From: Gail Johnson [REDACTED]@bhsvolunteer.org.uk>
Sent: 04 April 2024 07:03
To: M3 Junction 9
Cc: [REDACTED]@bhs.org.uk; Janice Bridger
Subject: Application by National Highways Limited Seeking Development Consent for the Proposed M3 Junction 9 Improvement Scheme

Application by National Highways Limited Seeking Development Consent for the Proposed M3 Junction 9 Improvement Scheme

Interested Party Reference 20036704

DRAWING TITLE  
 FIGURE 2.6 - THE SCHEME: TEMPORARY DIVERSION OF WALKING, CYCLING, AND HORSE RIDING ROUTES APFP REGULATIONS 5(2)(a) DOCUMENT REFERENCE 6.2

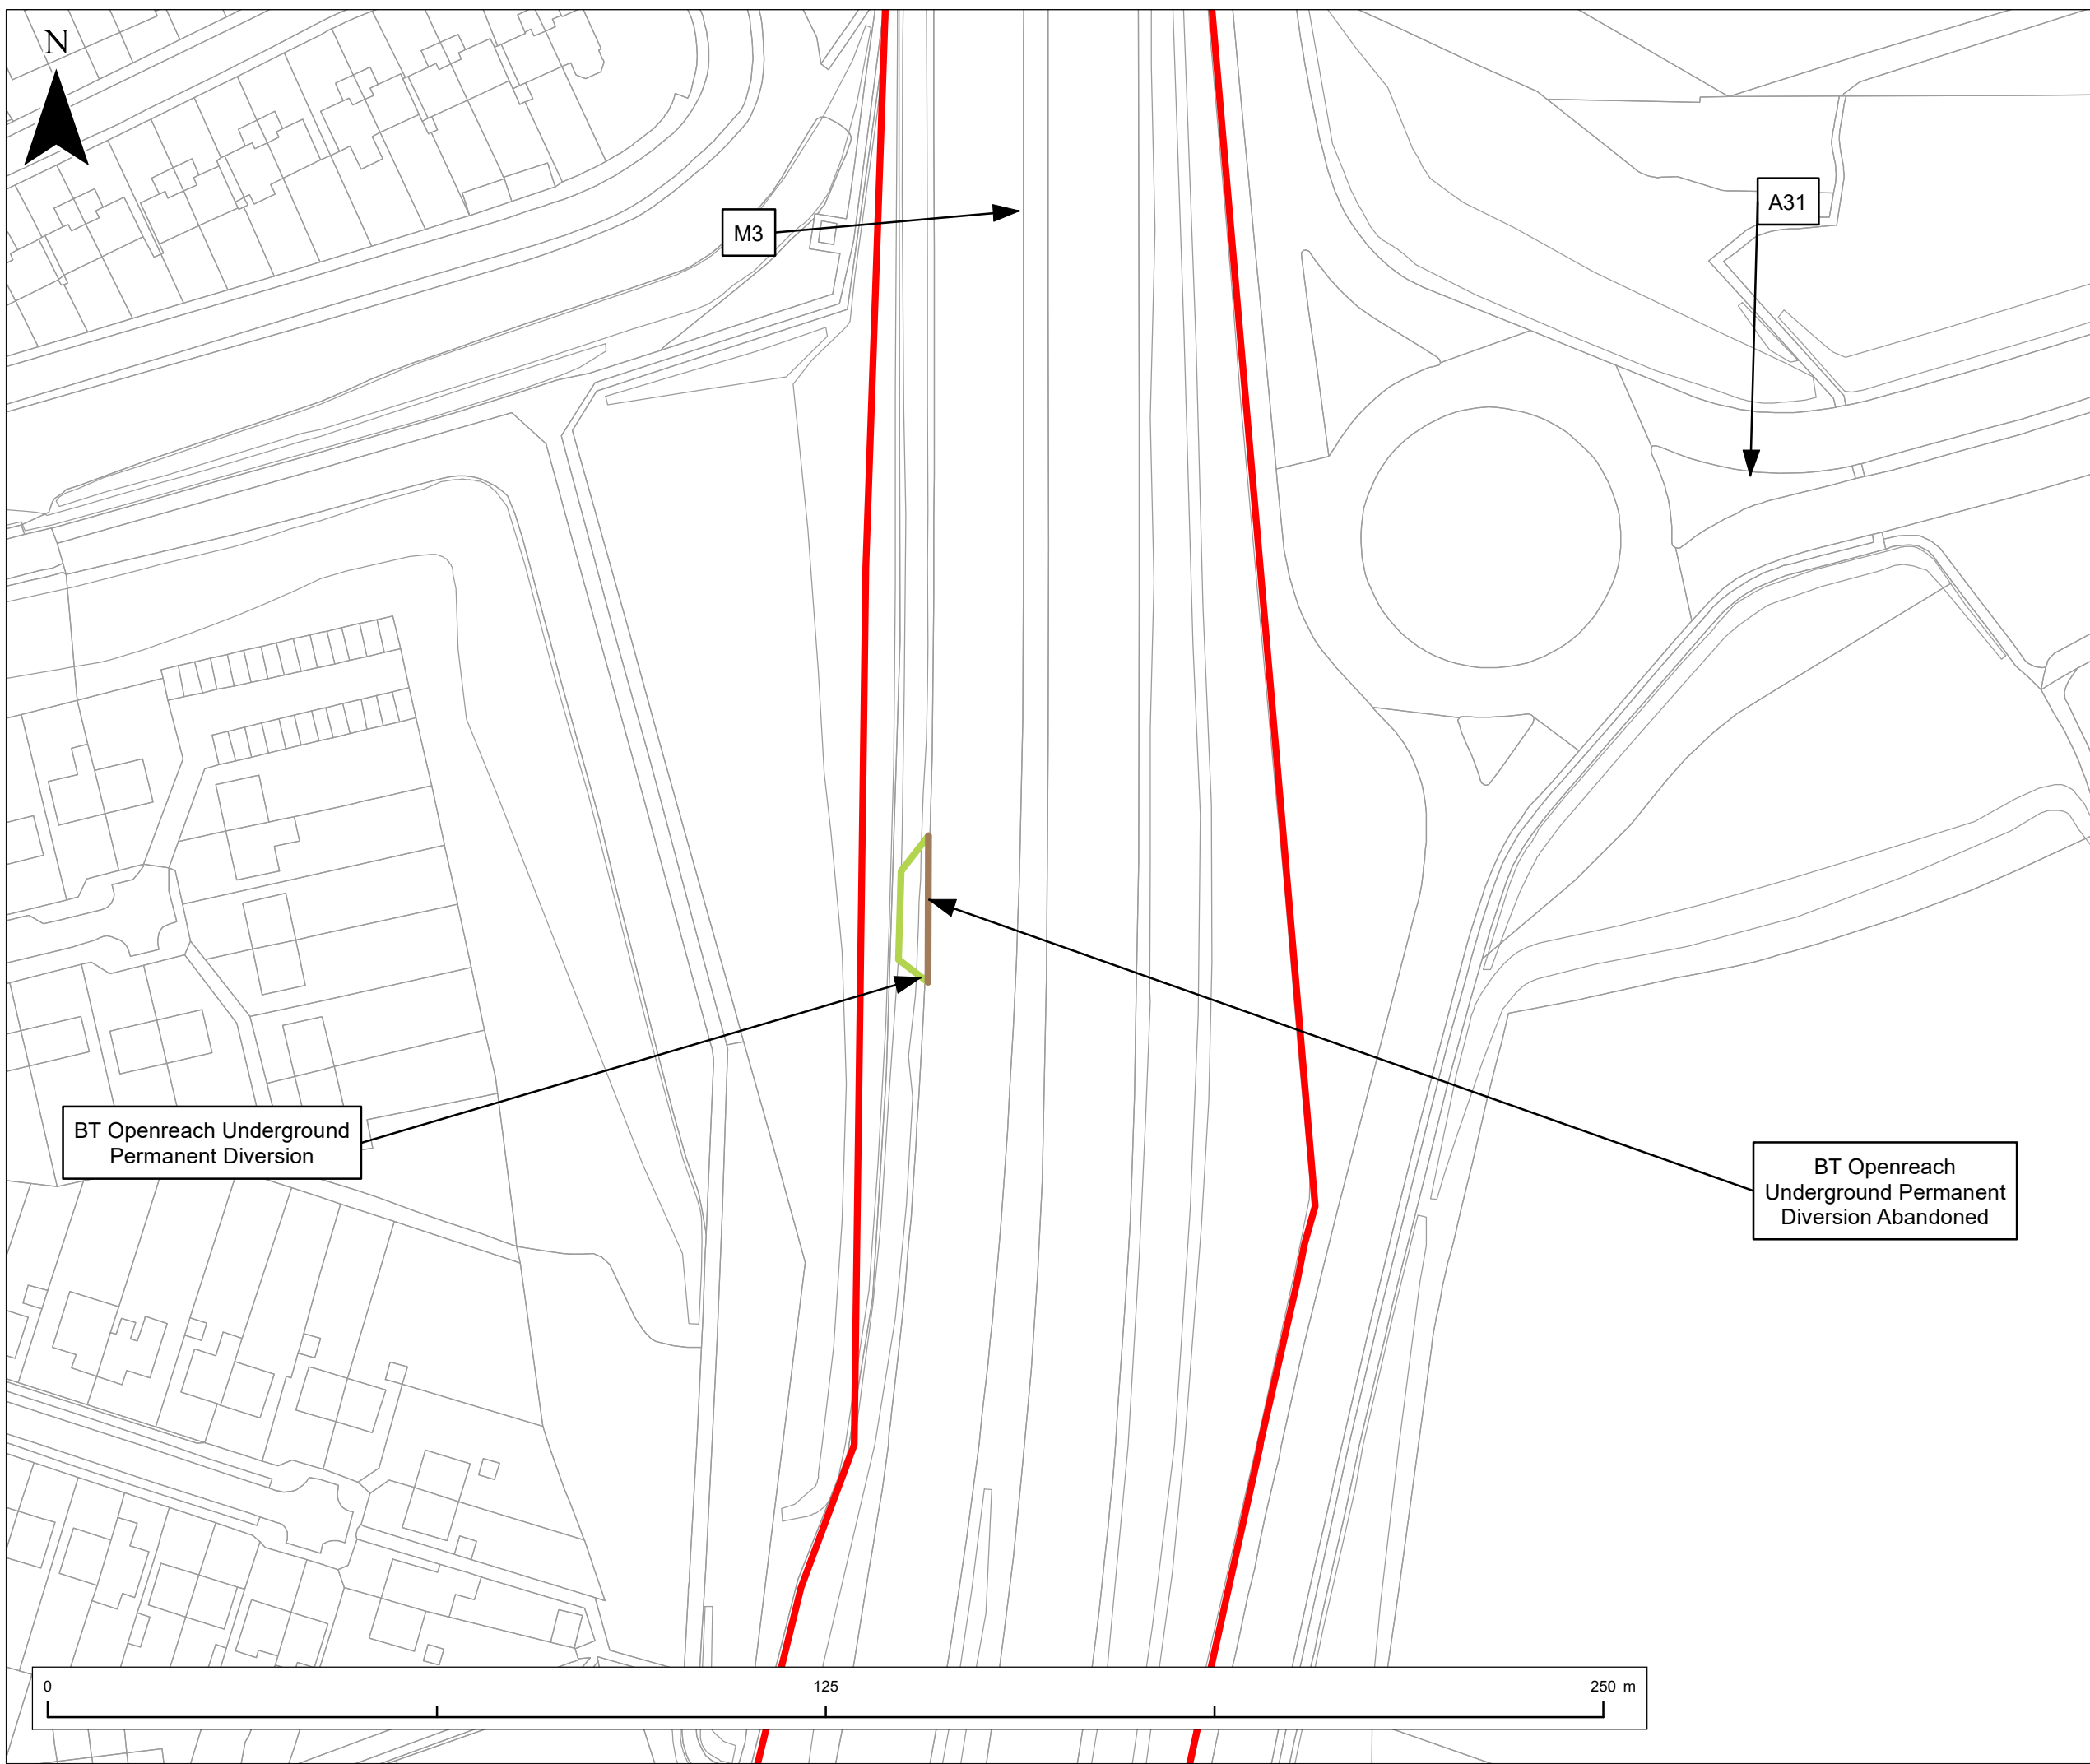
The location of site offices and diversions during construction may clash with cyclists, walkers and equestrians. We trust that the Side Agreement deals satisfactorily with these potential issues.
